YorkshireWater

13th January 2014

5 High Street, Thurnscoe, Rotherham, S63 0SU - Sewer build over

SITE PLAN 1/200

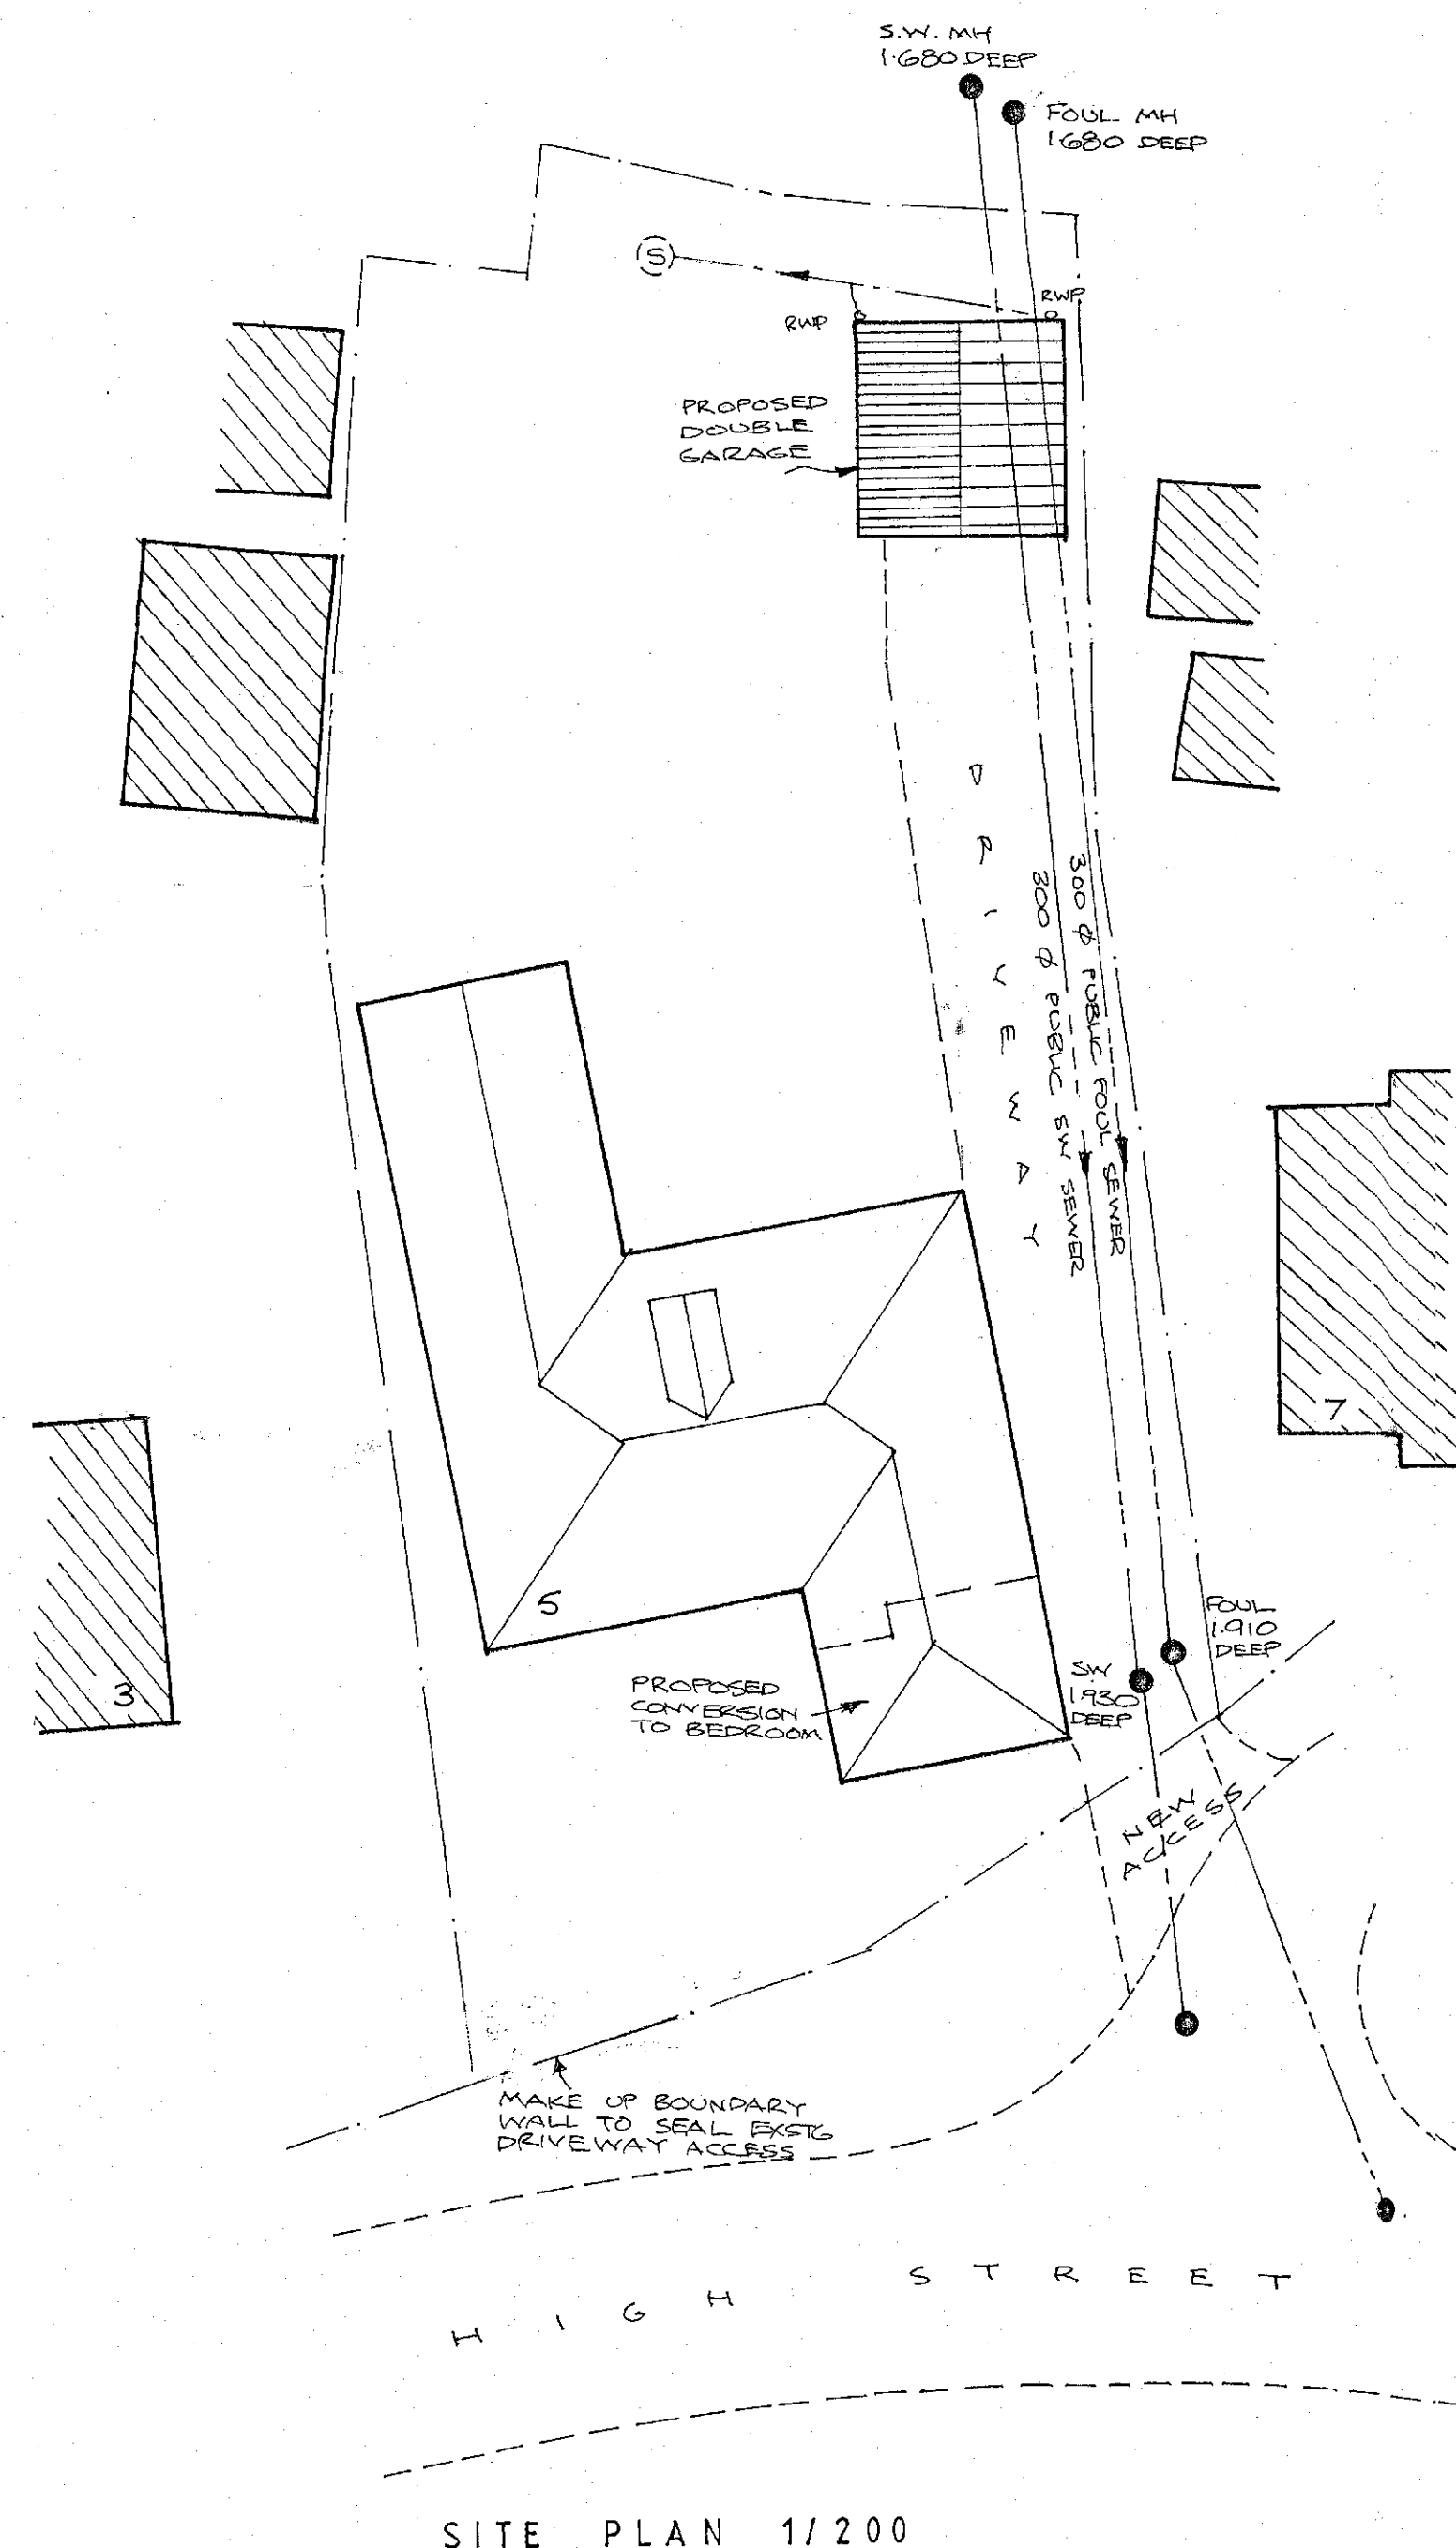
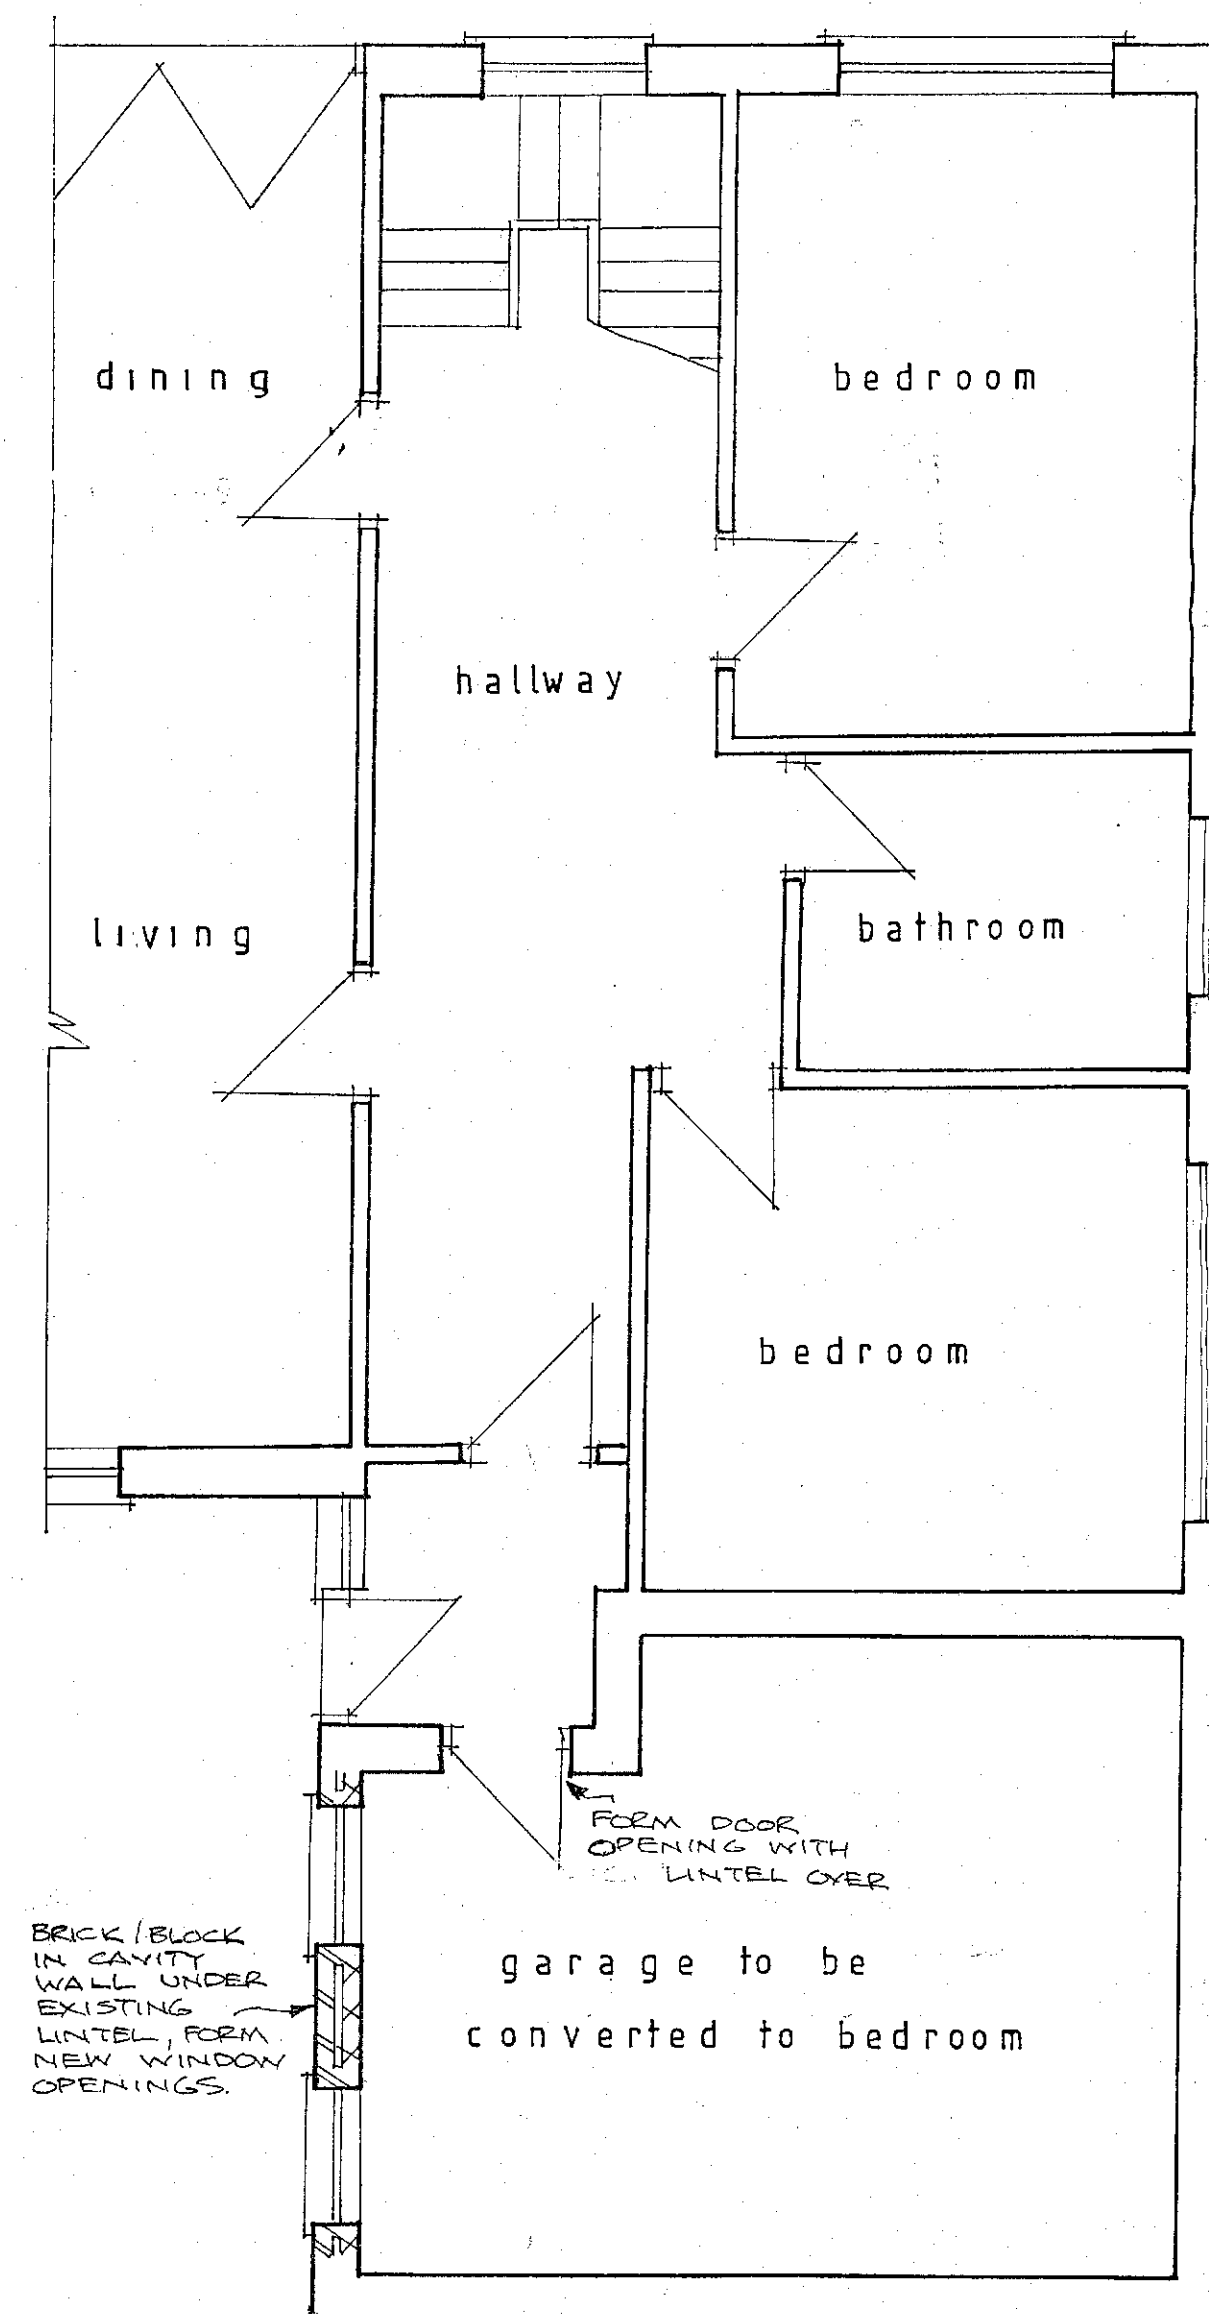
We have assessed the information provided and, in accordance with the criteria set out under the requirements of Part H4 Building Regulations, regret the proposals do not comply with Part H4 because a Yorkshire Water public **large diameter sewer** is within the extremes of the building footprint. **Please see the extract of our statutory public sewer map enclosed.**

Under Part H4 this is not acceptable because the sewer is 300mm in diameter.

Either the site layout will need to be adltered such that the building is at least three metres from the public sewer crossing the site, or the sewer will need diverting at the applicants expense in accordance with S185 of the Water Industry Act 1991.
